Your ref: SSD 5175 Mod 3 &
SSD 8588
File no: MC-12-1769

**Projects: SSD 5175 Mod 3 Eastern Creek Business Hub s96(1A) to amend
the total Gross Floor Area
SSD 8588 for the construction of a retail centre on approved Lot 2
(Stage 1)**

Re: Response from Council

**12.5m LARGE RIGID VEHICLE  
 SWEEP PATHS**

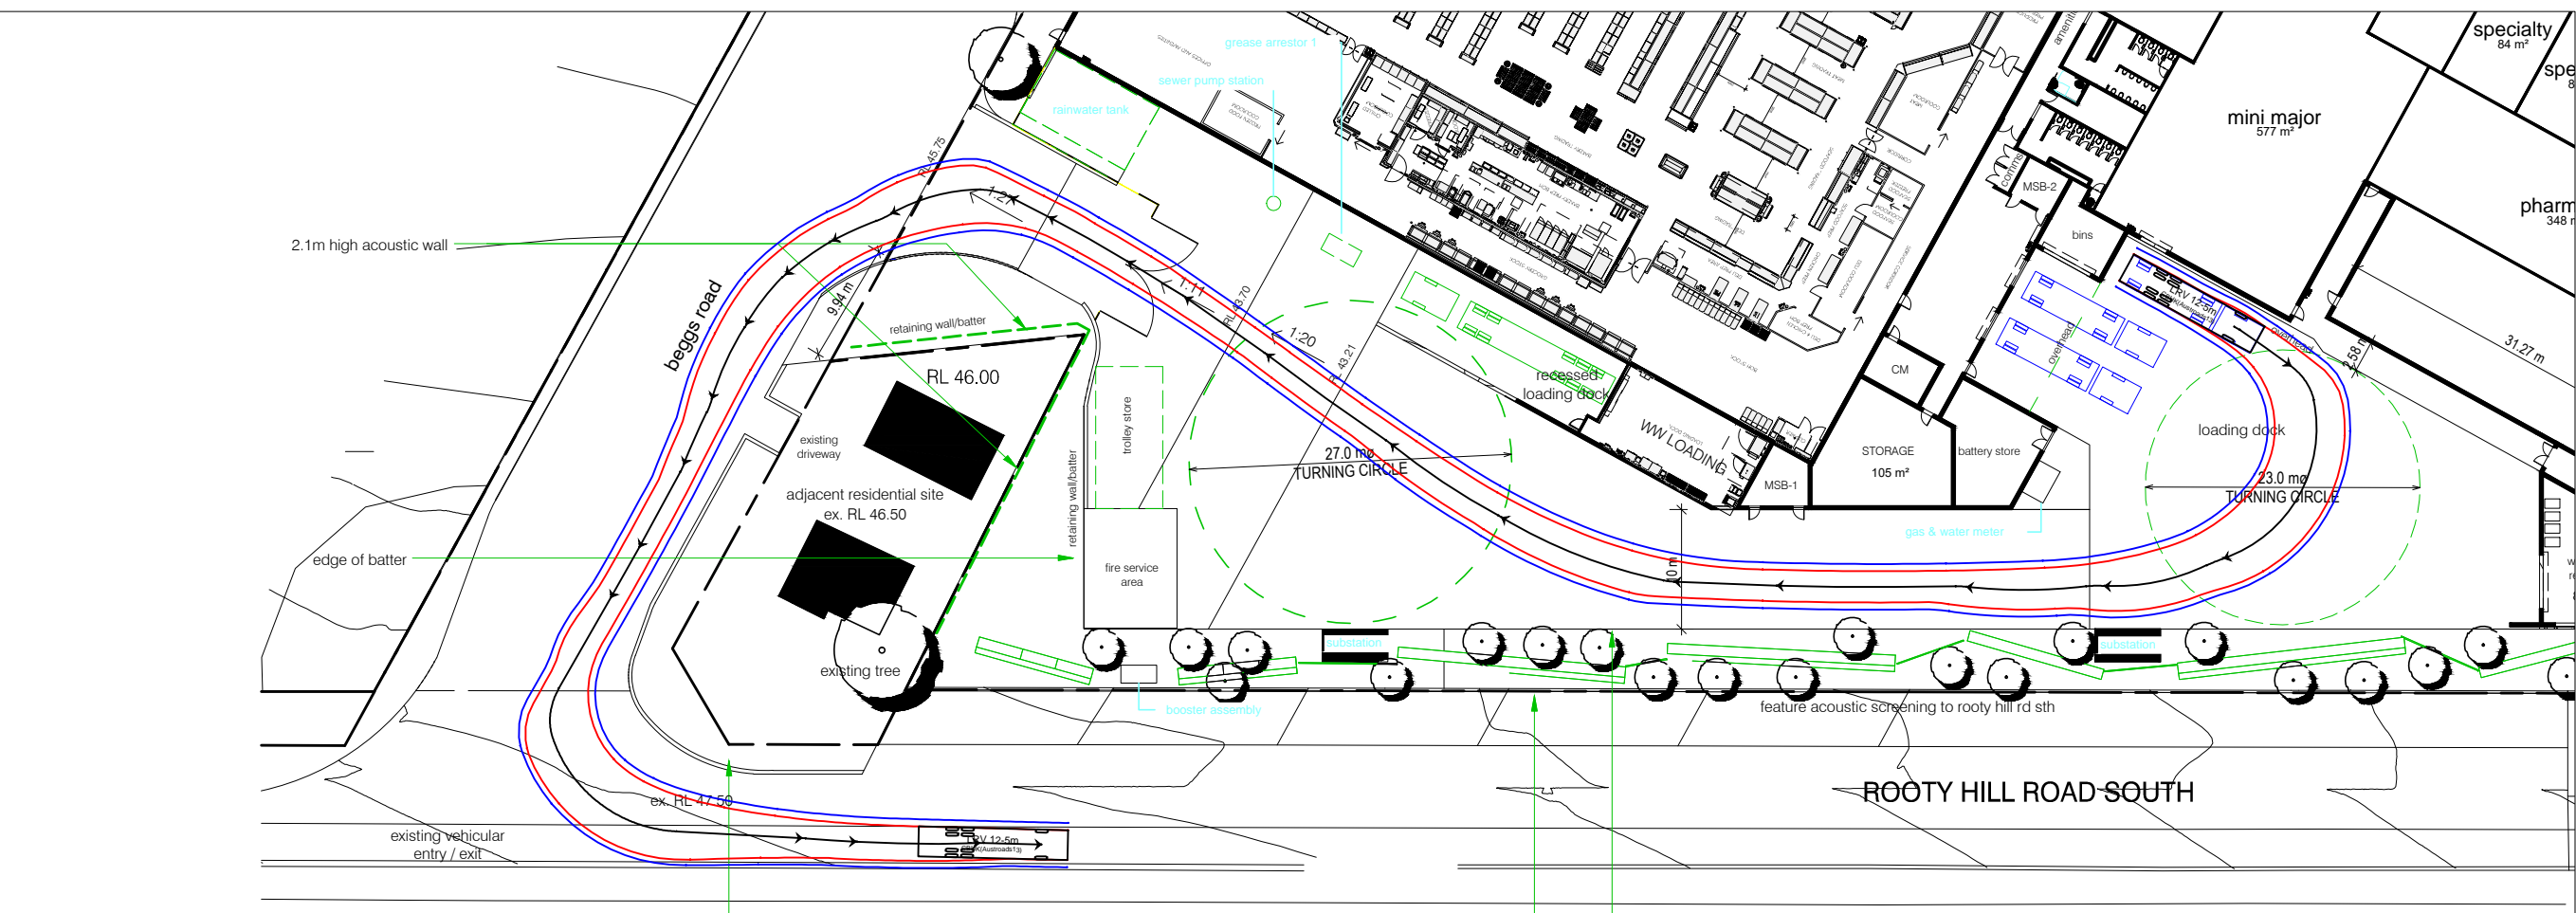
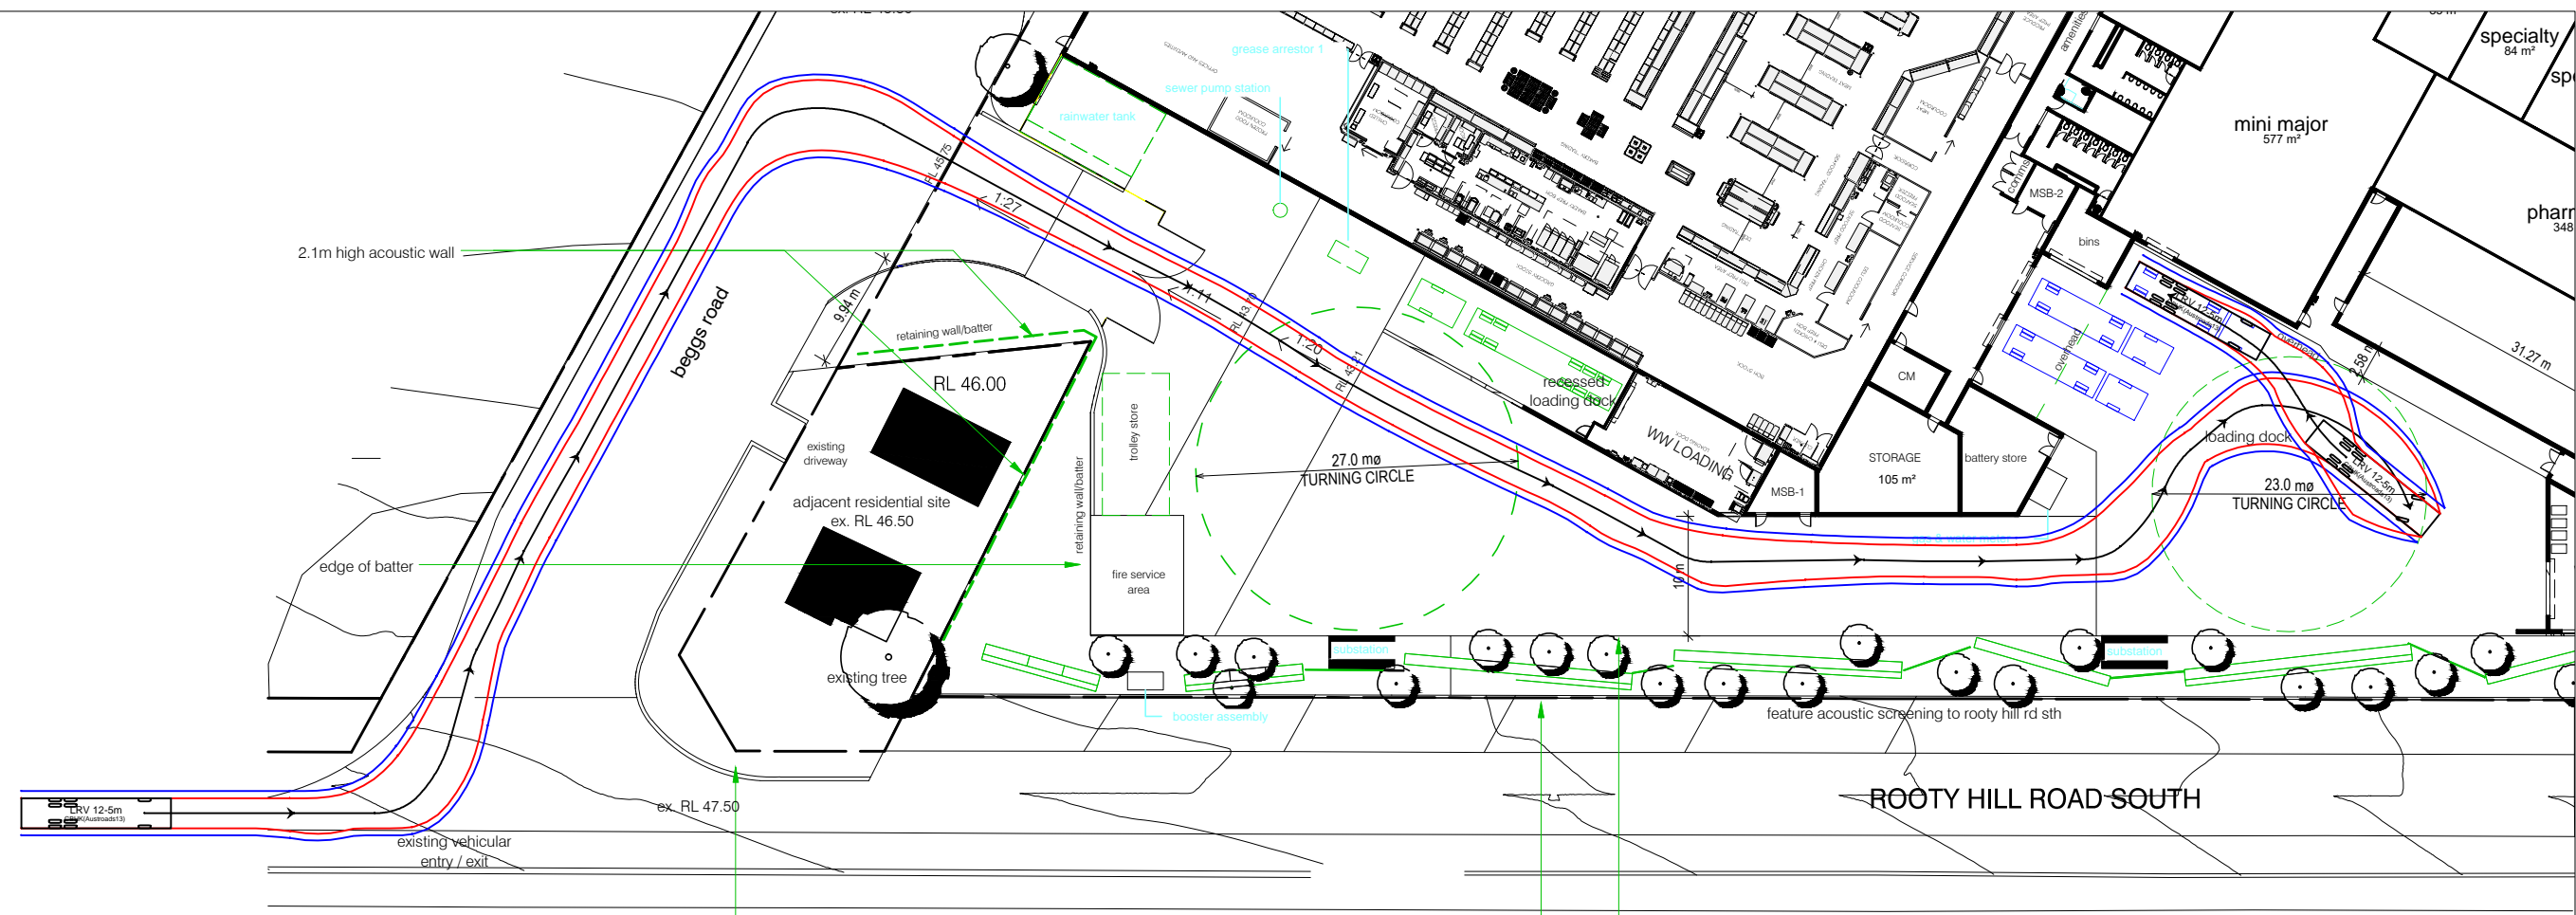
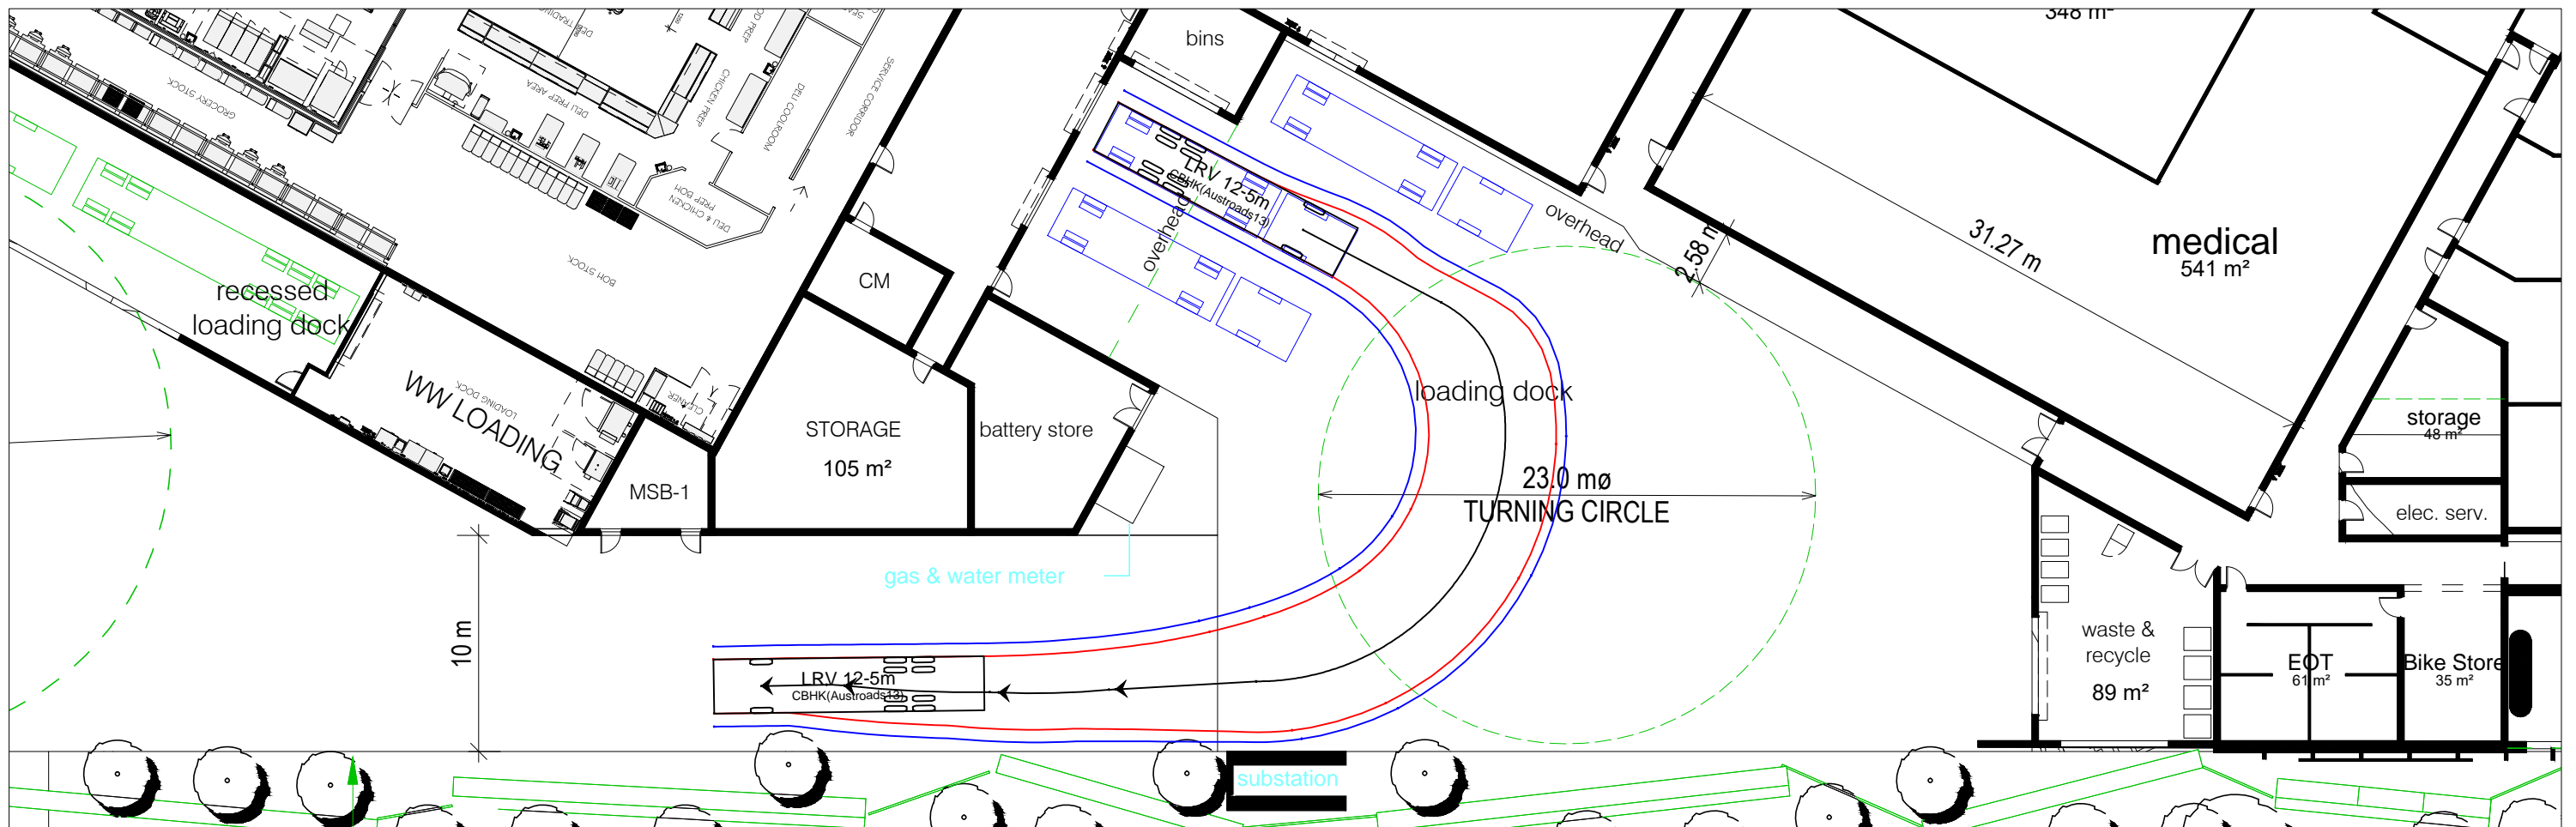
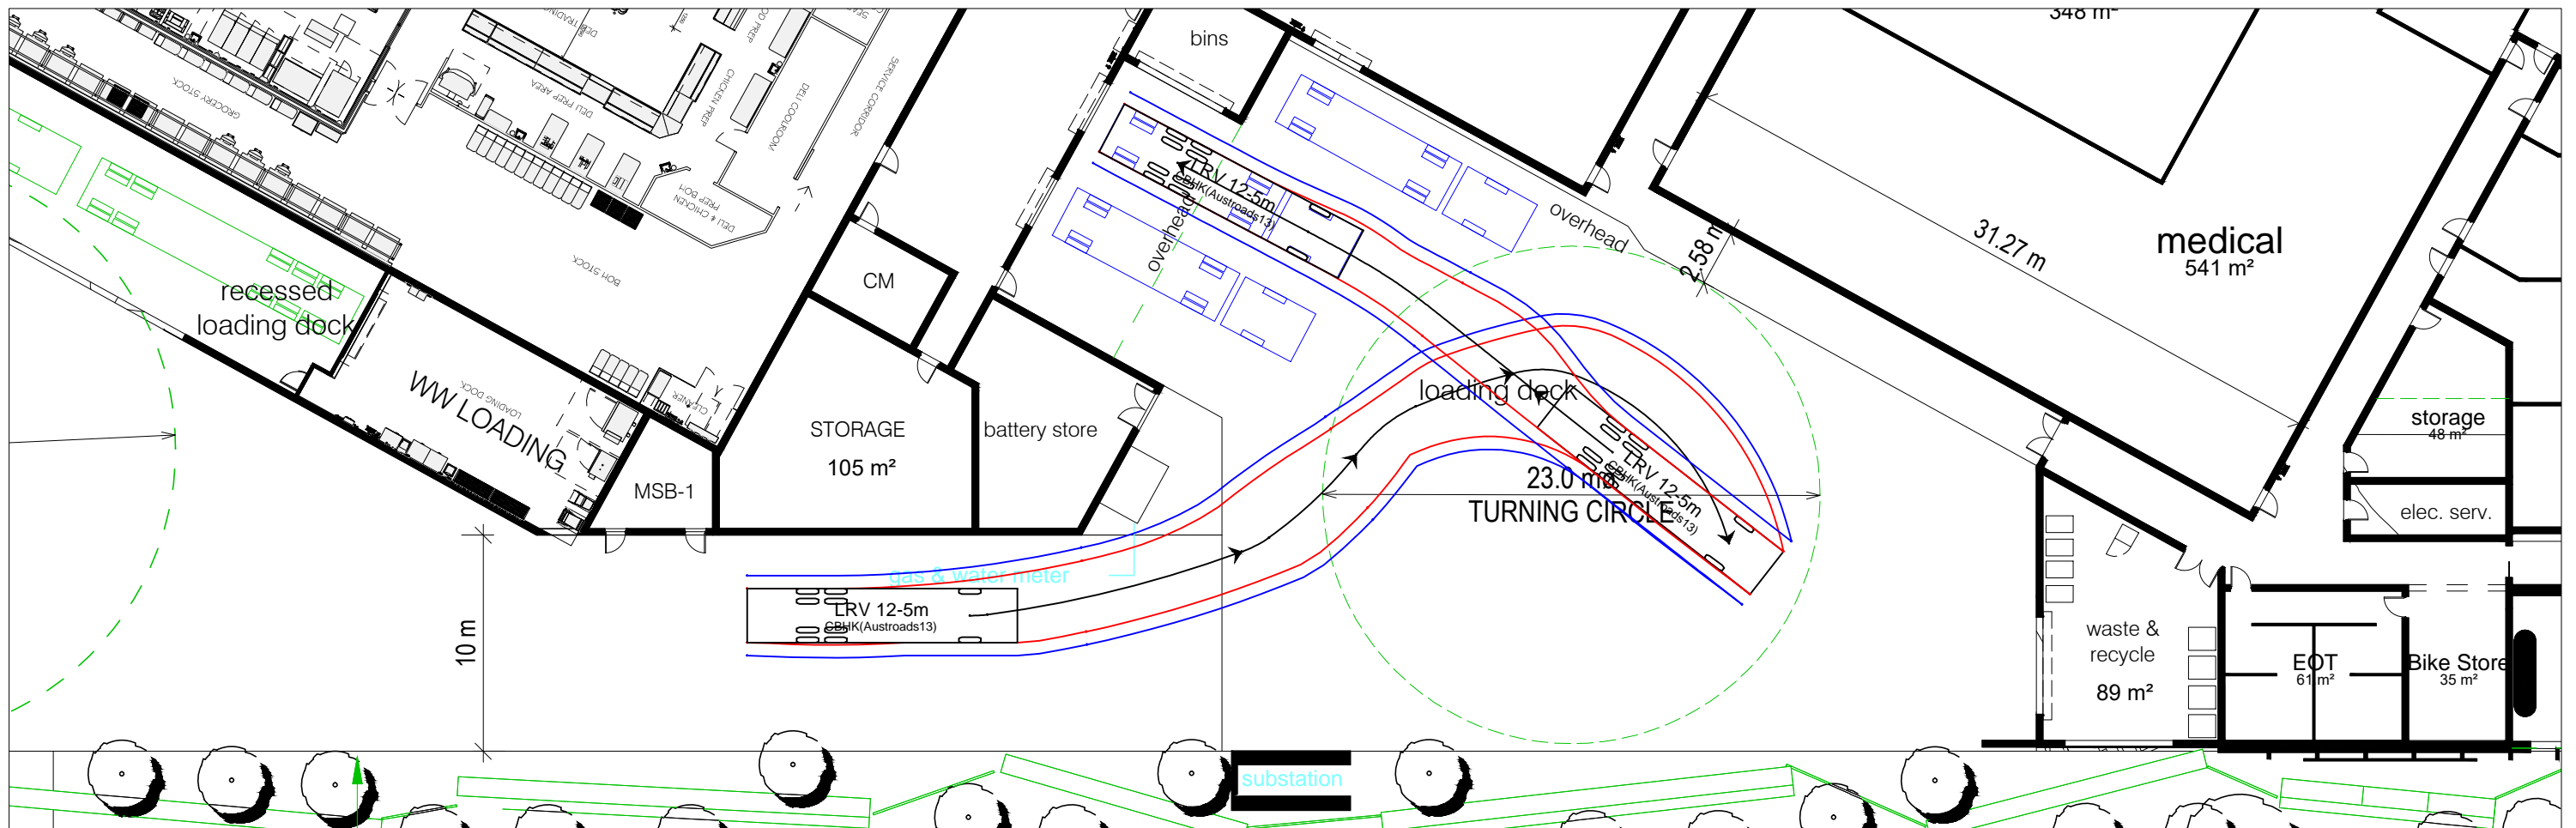
Drainage and Engineering Matters
<p>This item is still being assessed and a response will be provided separately.</p>
Traffic Management Matters
<p>The following comments are provided by Council's Access and Transport Management Section (ATMS):</p> <ol style="list-style-type: none">1. Council's local industrial road is 20.5 m wide which includes a 13.5 m wide carriageway and a 3.5 m wide footway on each side. The proposed 12 m wide carriageway does not comply with Council's DCP requirement and is not supported.2. A turning head in the form of a cul-de-sac with a carriageway radius of 13.5 m is

required at the end of Beggs Road. We do not support a three point turn by a truck on a public road.

1. The Beggs Road carriageway is to have a width of 13.5 m.
2. The end of Beggs Road is required to have a turning head in the form of a cul-de-sac with a carriageway radius of 13.5 m.
